Fosse Green Energy

EN010154

9.31 Applicant's Response to Deadline 5
Submissions

12 May 2026

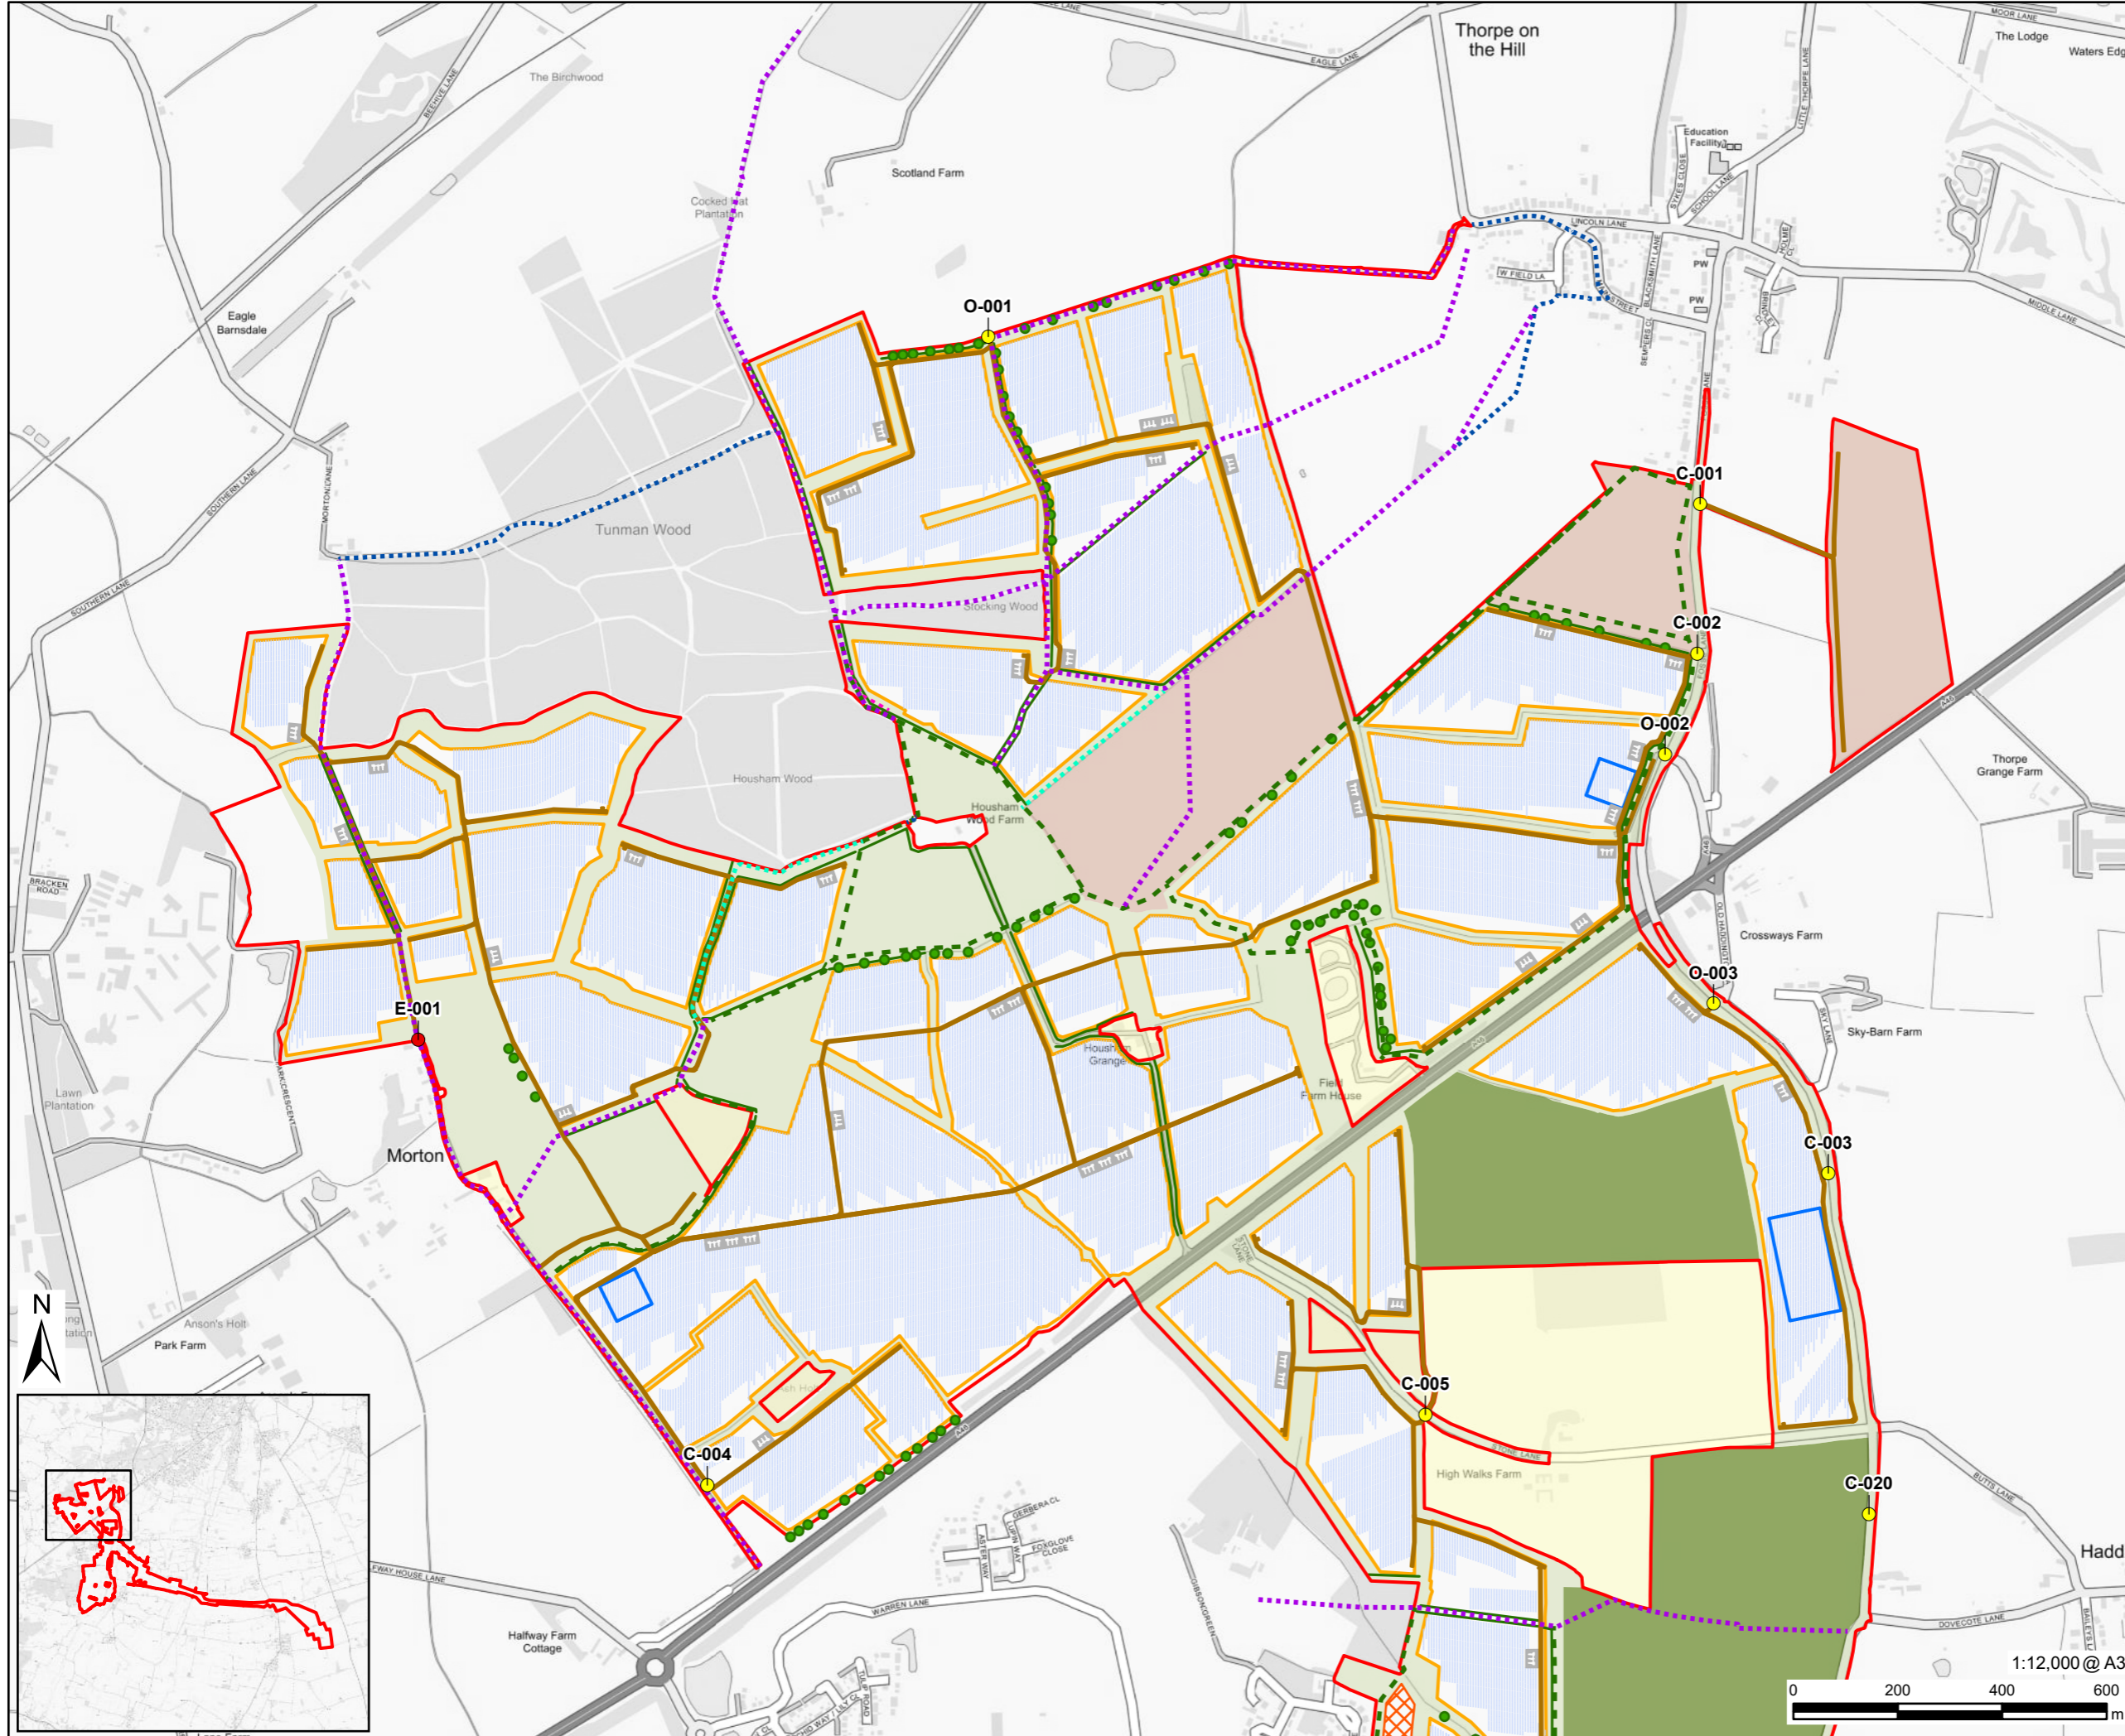
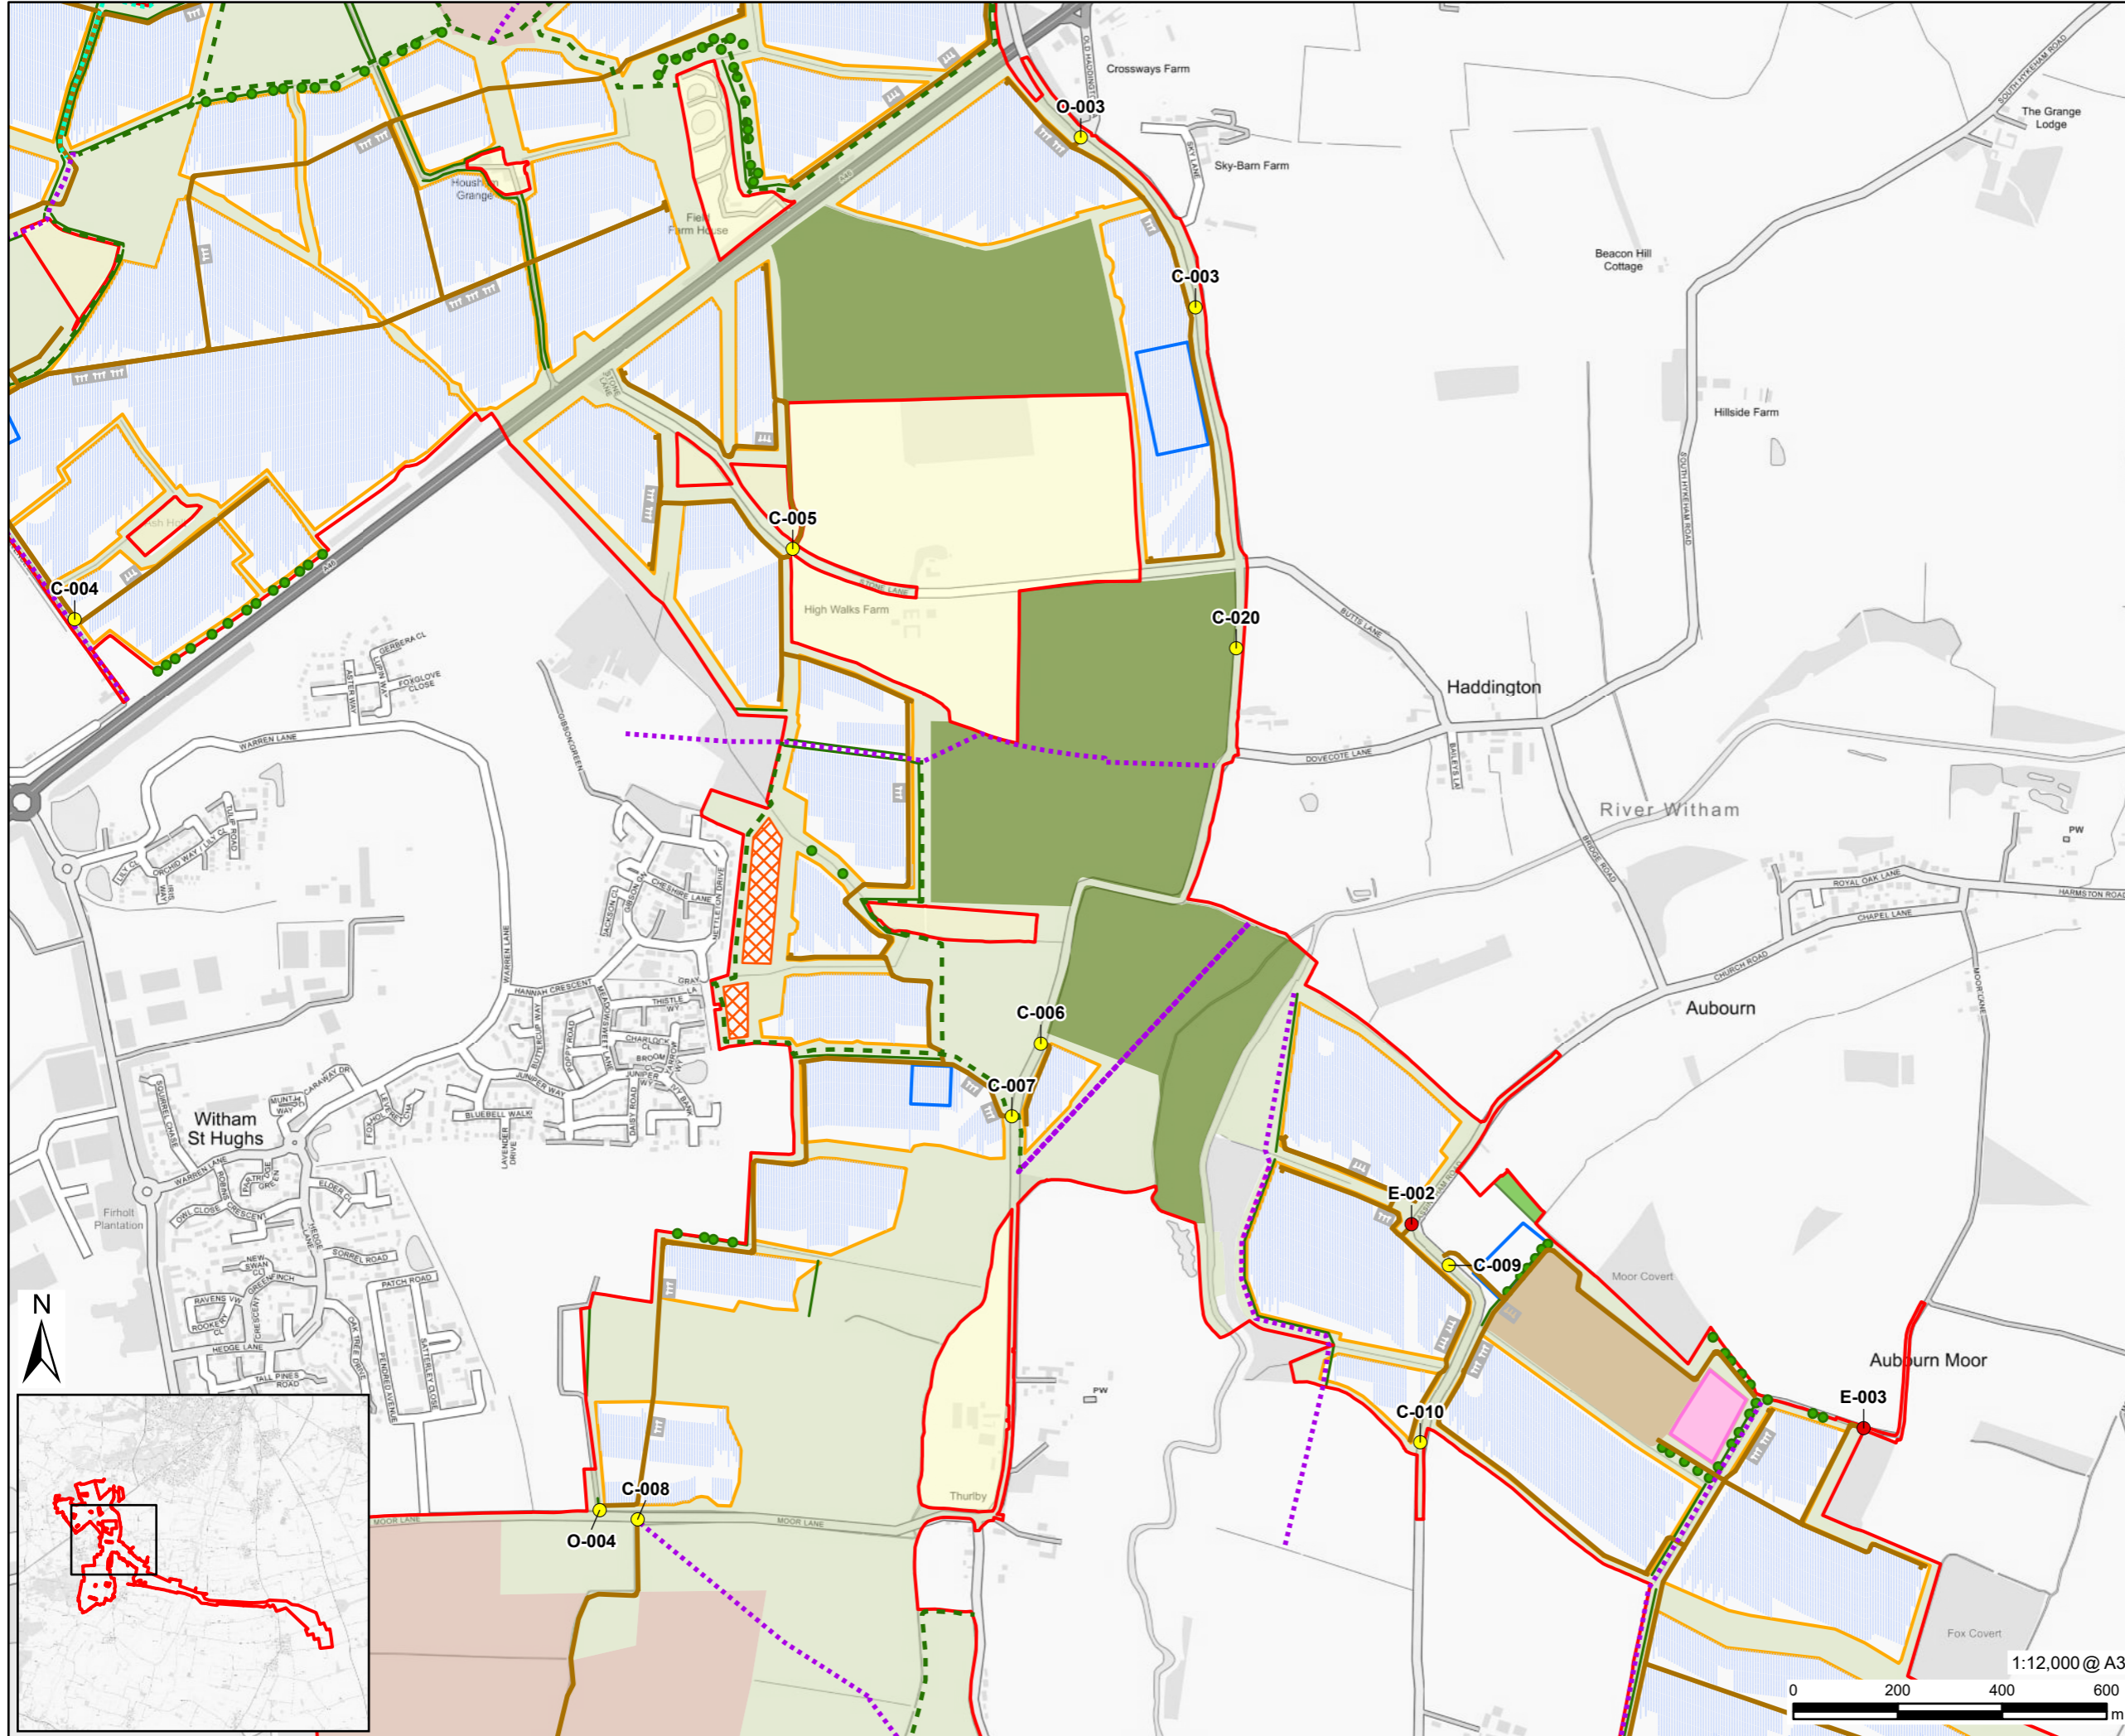
Interested Party	Theme	Comments from any party on any submissions and any information received at deadline 4	Applicant Response
LCC	Comments on D4 documents - Layout	Site Layout Plan Revisions - Indicative Fixed South Facing Layout (Rev 3) and Indicative Single Axis Tracker Layout (Rev 3) [REP4-006 & REP4-007, respectively) LCC assumes that the overall red line boundary remains unchanged, and thus LCC's previous comments in respect of minerals & waste safeguarding remain unchanged.	The assumption that the DCO Site red line boundary remains unchanged is correct. The Applicant's position regarding minerals and waste safeguarding are set out the Applicant's Response to Deadline 4 Submissions [REP5-025], the Applicant's Response to the Examining Authority's First Written Questions [REP2-029] and the Applicant's Response to Deadline 2 Submissions [REP3A-025].
LCC	Comments on D4 documents - FCEMP	Framework Construction Environmental Management Plan (Rev 5) [REP4-009] LCC notes and appreciates the addition of paragraph 2.2.3 which states the applicant will inform LCC of the date of final commissioning once it has occurred. Section 2.9: Recovery, Recycling and Disposal of Waste – No changes to comment on here, but we note that the Table of Contents mistakenly labels this as 'Section 2.8'. In respect of archaeology LCC's previous comments stand, including that 'The full extent of any preservation in situ areas or areas identified for further archaeological work will need to be fenced off to ensure that there are no groundworks, plant movement, storage or any other developmental works which may cause damage to the currently surviving archaeology.' Within Table 2, cultural heritage, CH-C1 states that 'The detailed CEMP(s) will include an action plan detailing the required mitigation in the event that unplanned activities threaten the preservation of known buried archaeological remains.' Again, this will also need to include unevaluated areas as well as known archaeologically sensitive areas. This document makes reference to Environmental and Ecological Clerks of Work, as stated in our previous comments, an Archaeological Clerk of Works is also required.	Regarding an Archaeological Clerk of Works, it should be noted that CH-C1 of the Framework CEMP [REP5-011] notes that "If deemed necessary, an Archaeological Clerk of Works can be agreed." Matters of temporary or permanent fencing to protect known or potential buried archaeological remains are referenced in the draft Framework WSI [REP3A-027] (at paragraph 3.19) The Framework CEMP [REP5-011] correctly identifies the section 'Recovery, Recycling and Disposal of Waste' as Section 2.8 within the Table of Contents and within the document itself.
